**WELWYN HATFIELD COUNCIL – DEVELOPMENT CONTROL**  
**DELEGATED REPORT**

<b>APPLICATION No:</b>	<b>N6/2008/962/FP</b>
------------------------	-----------------------

**DESCRIPTION OF PROPOSAL:** It is proposed to erect a three storey extension on the north – eastern side of the property. The proposed extension would feature materials and fenestration to match the existing dwelling and would measure 22.1 metres wide, 15 metres deep and 12 metres tall.

GROUND FLOOR PLAN
EXTENSION SHOWN SHADED

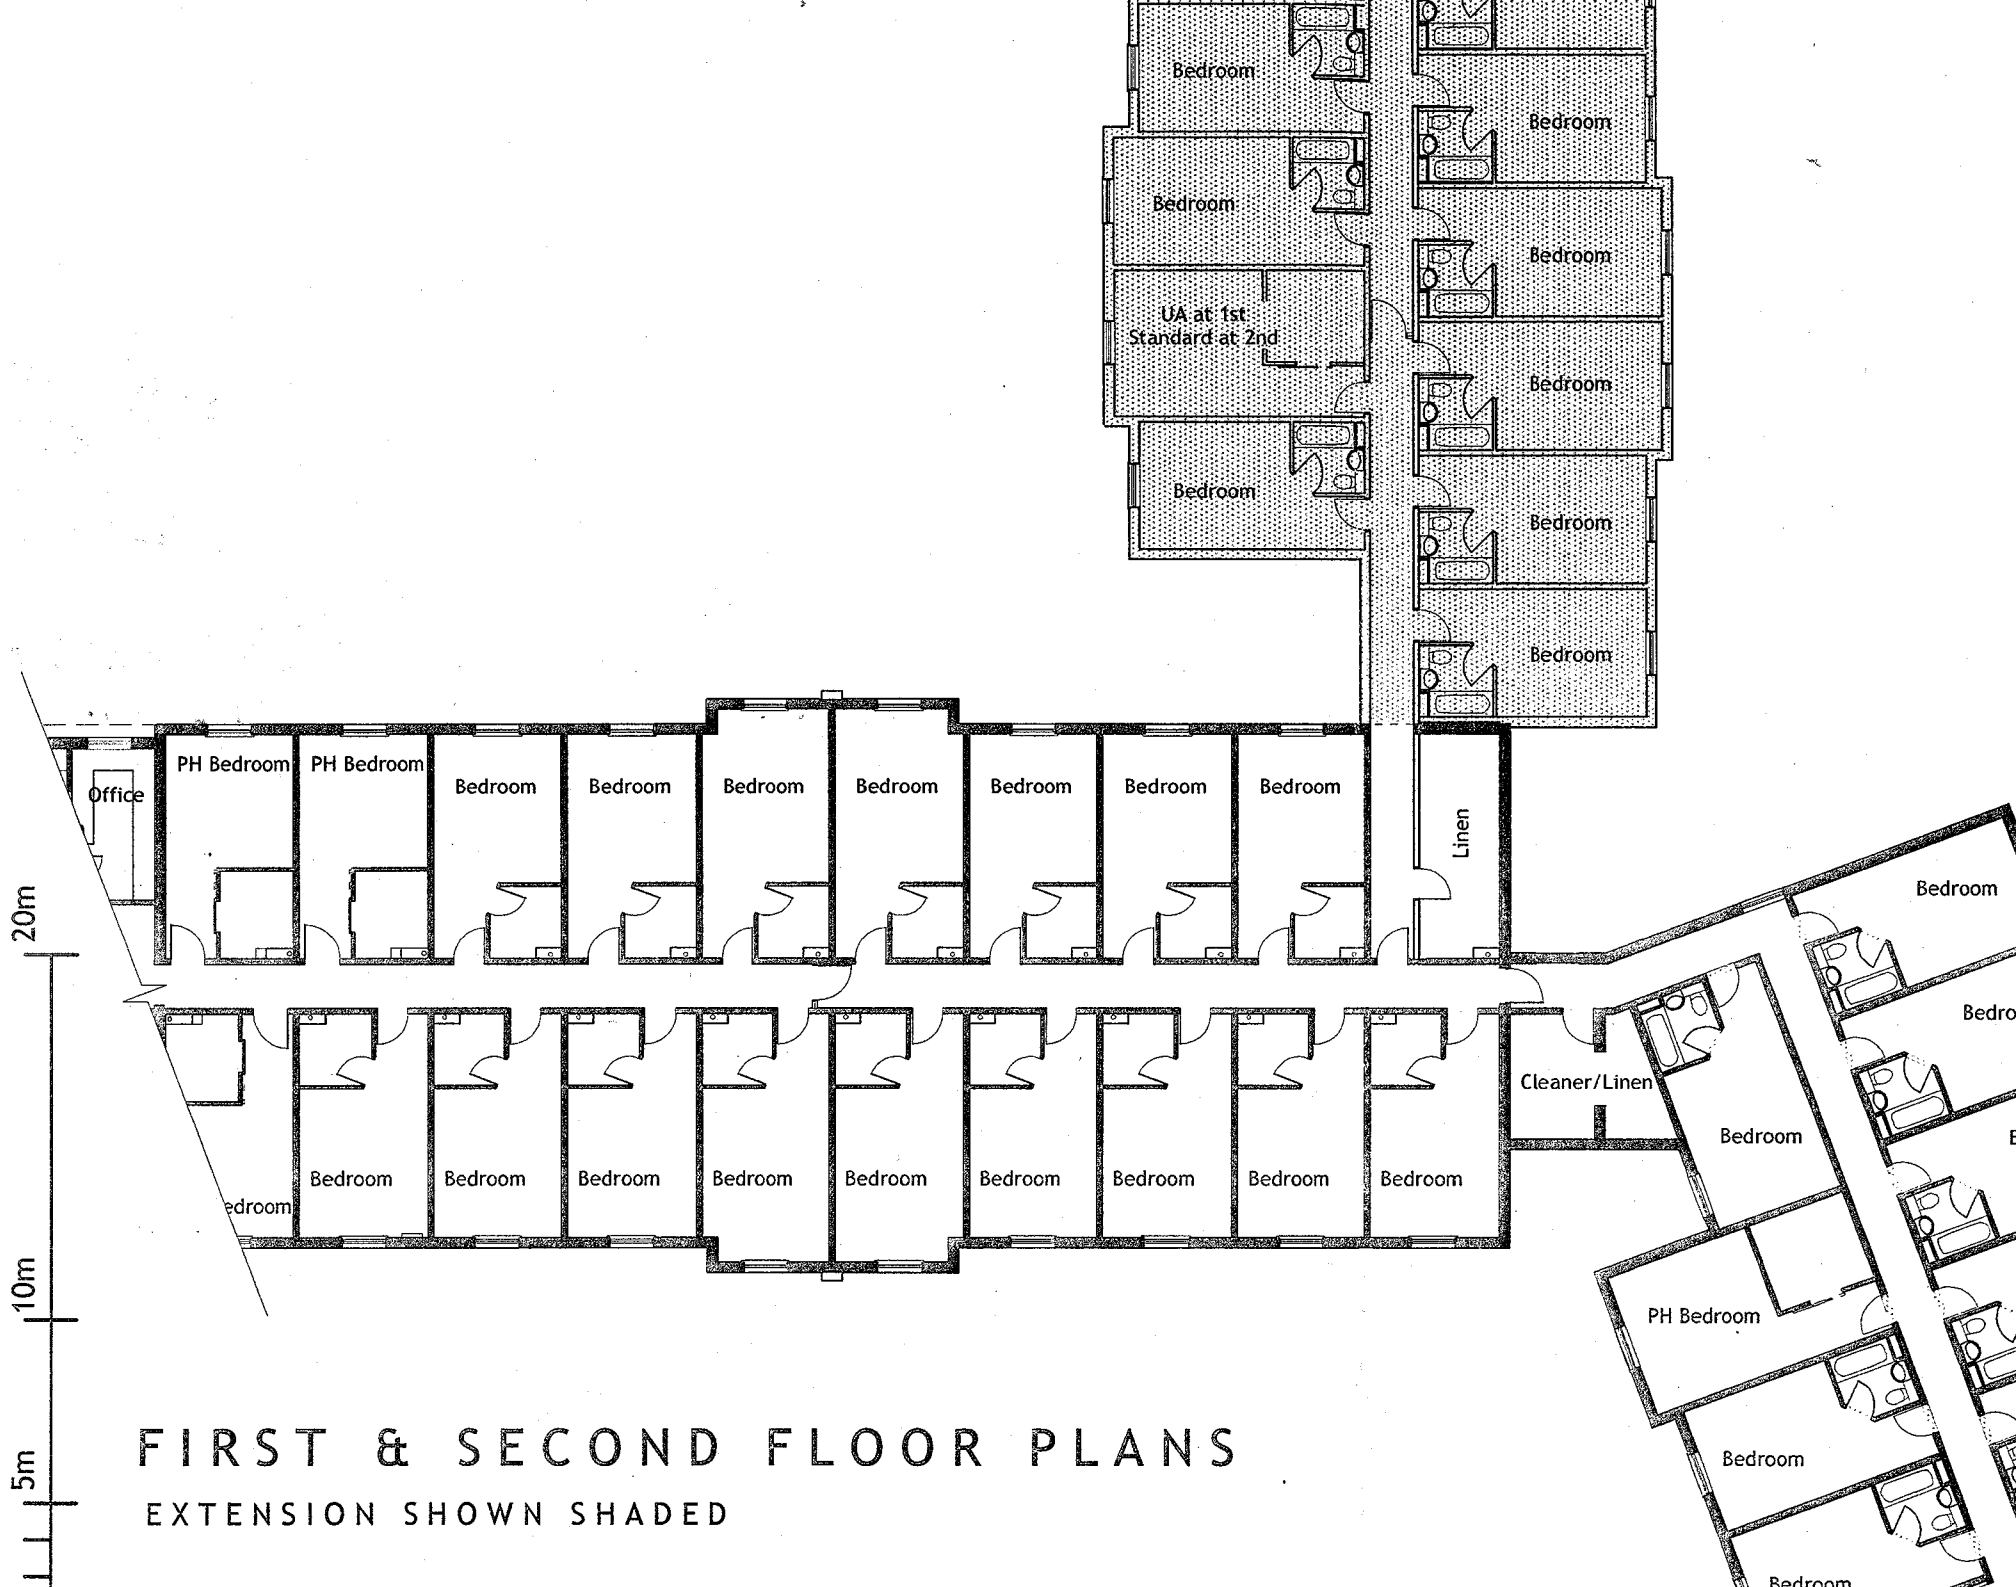
Unfortunately the applicant has failed to submit a detailed account of the number of staff that will be present on site at any one time or clearly indicate where the provision of the 167 parking spaces would be. They have also not provided information as to the amount of space used for conference facilities, whilst the existence of conference facilities has been mentioned in the sustainability checklist. Indeed, whilst the application has stated that there would be the provision of 167 parking spaces the submitted drawing [2587/P2B] annotates that there would only be a maximum parking allocation of 154 spaces.

In terms of the actual number of bedrooms, it is noted that the submitted drawings [2587/P3A & 2587/P4A] floor plans do not fully annotate the total number of bedrooms on the site, which is shown at a total of 115. In addition to this the design and access statement submitted with the application states that “there are currently 90 bedrooms and the proposed extension will add another 30 bedrooms making a total of 120”.

If there was an allocation of 154 spaces as shown in the submitted drawing [2587/P2B] then the applicant would only provide 73.68% of the total maximum standard of car parking spaces. According to the applicants' design and access statement and parking survey the current usage of the car park would justify 0.77 spaces per bedroom or less. In this instance, in line with other considerations, the proposal would result in a total maximum requirement of approximately 92 spaces for hotel rooms. This in accordance with the other requirements (outlined in the table above) would result in the proposal requiring 181 car parking spaces. The proposed
